Re: Planning Application 18/0435

Address: 32 Hall Street Clitheroe BB7 1HJ

Description: Demolition of existing property and associated outbuildings and erection of six three-bedroomed town houses.

Simon Hardie
Highways Development Control
Lancashire County Council

PROPOSED SITE PLAN

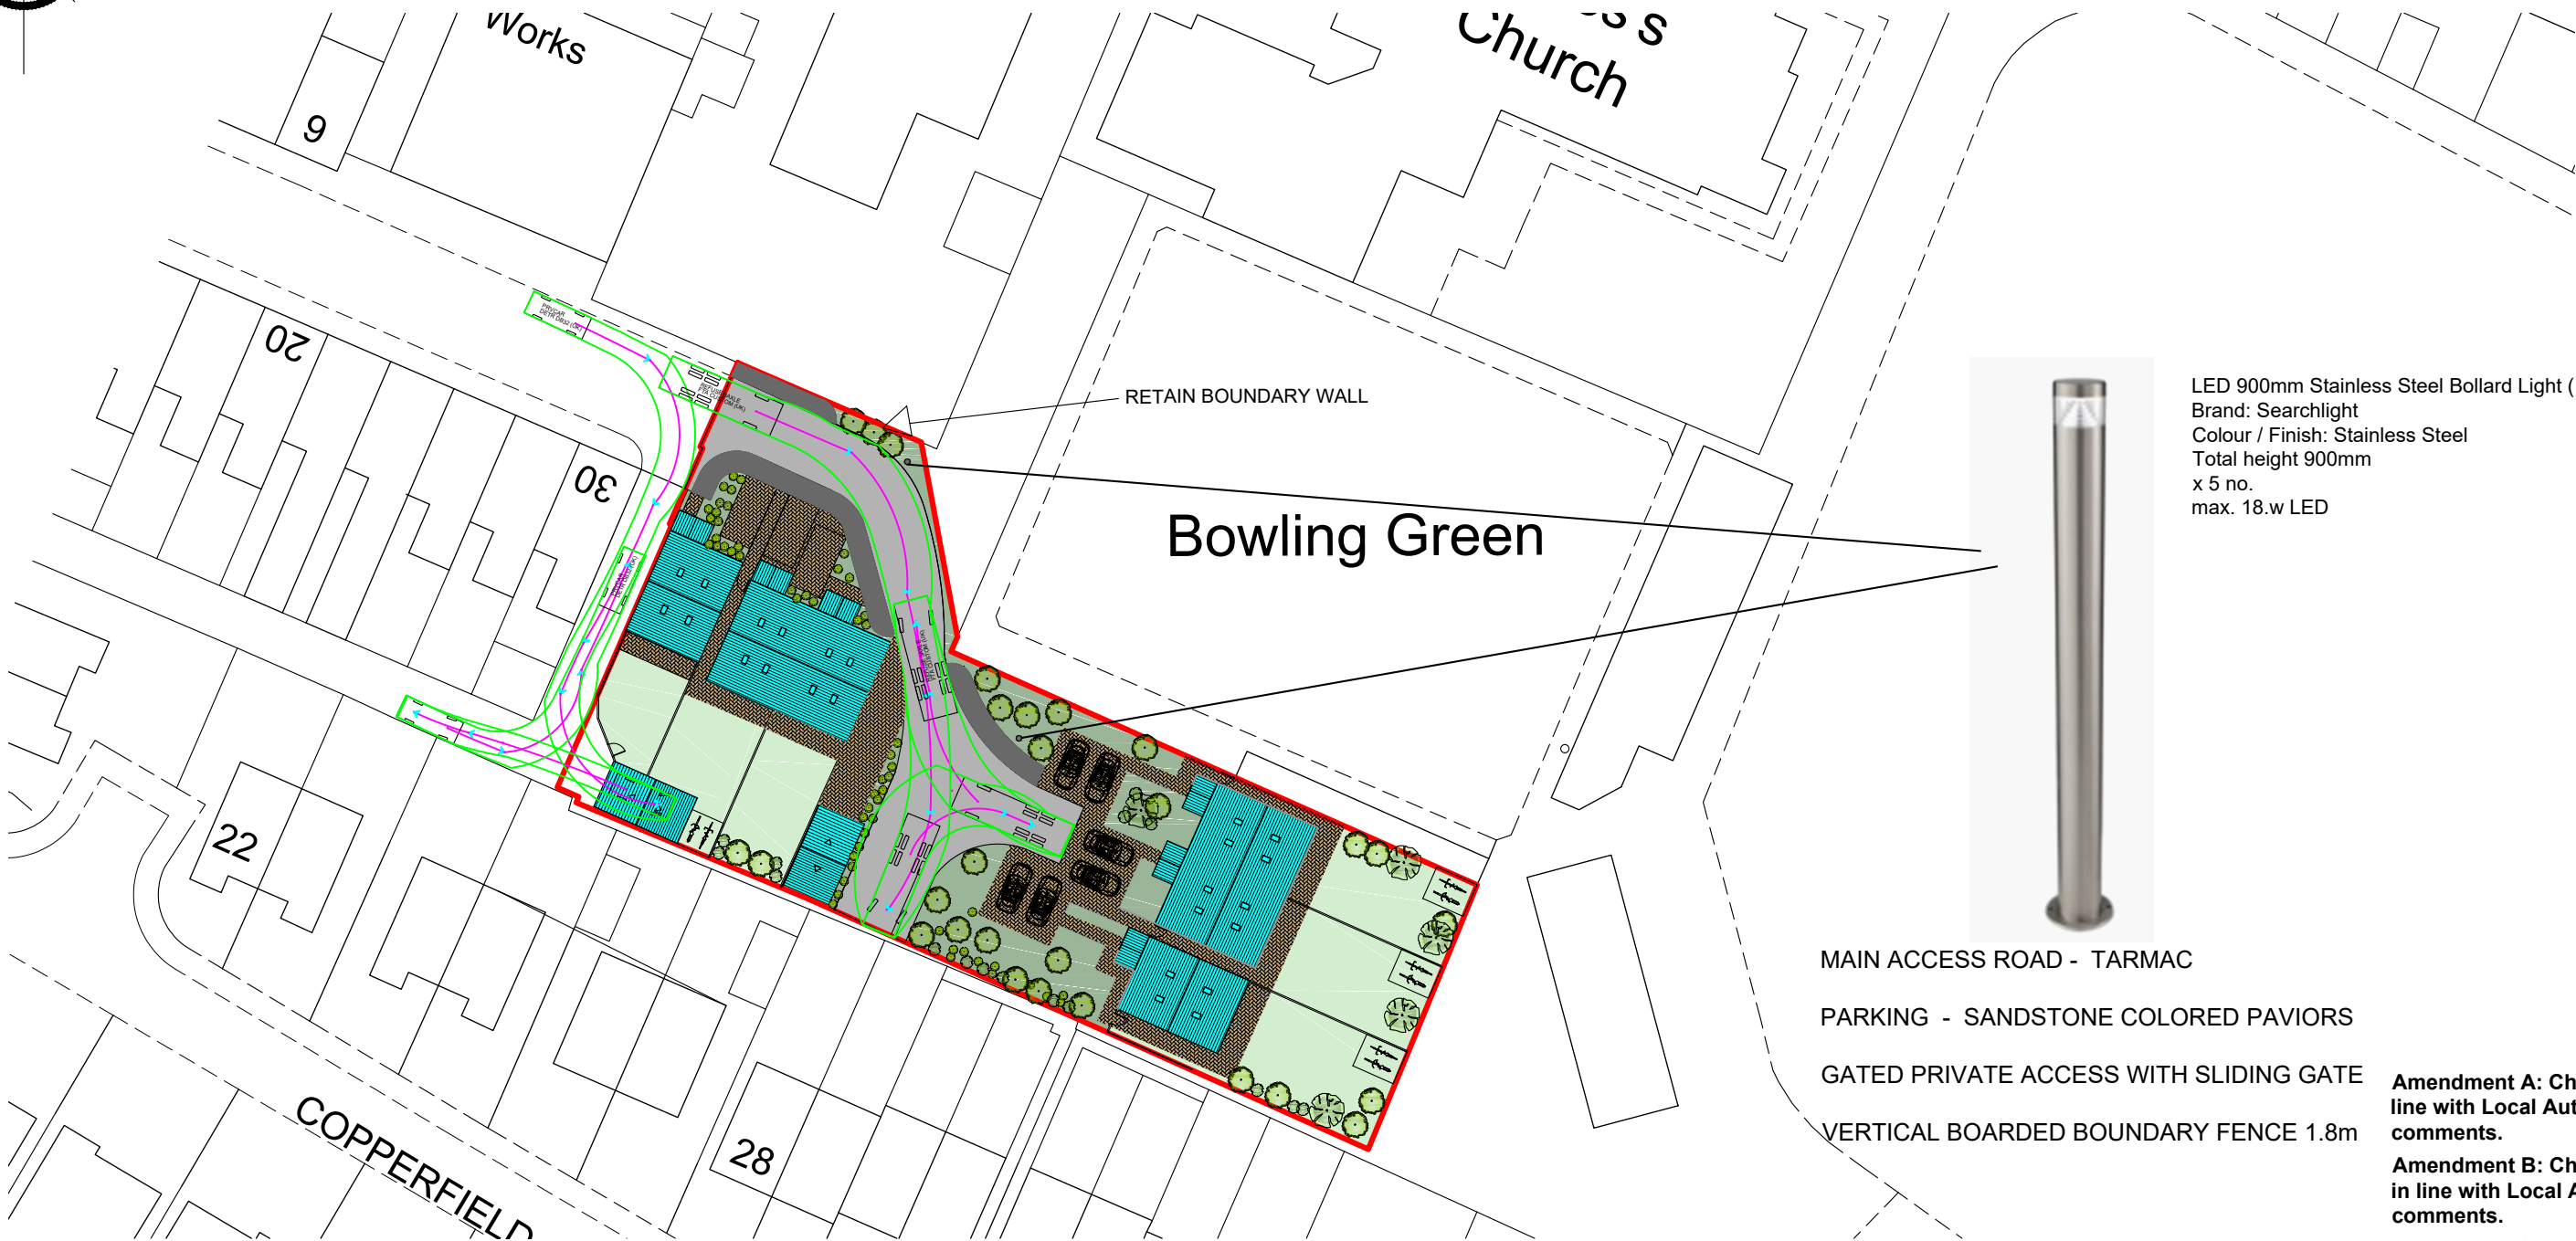
- The alteration to the access gate now blocks the access to the front of plot one, there is a concern that although a garage has been provided, its access will be tricky at best, which is likely to lead to the garage not being used much and the vehicle being parked in the back lane or elsewhere within the new development causing an obstruction
- The lane to the new garage at plot one appears to be quite narrow, a swept path analysis should be undertaken to ensure suitability, it is expected that a large family car such as a Ford Mondeo would be used, the garage should be entered in a forward and reverse gear, with access being past the gable of no 30 Hall Street
- There still does there appear to be any provision for pedestrians within the development.
- Nor has there been any indication regarding the provision of any street lighting or surface water drainage.

- A swept path analysis should be undertaken to ensure that a refuse collection vehicle can enter and exit the development in a forward gear. This should be repeated in the other direction as this may be preferred by the driver and with a 3 axle 9.3m long vehicle as used by Ribble Valley Borough Council.
- With the exception of the plots with garages, suitable covered and secure storage should be provided for at least 2 cycles per dwelling.
- Although a vehicle is shown on Plot 3, the driveway is not long enough to accommodate a parking space and should not be shown as such
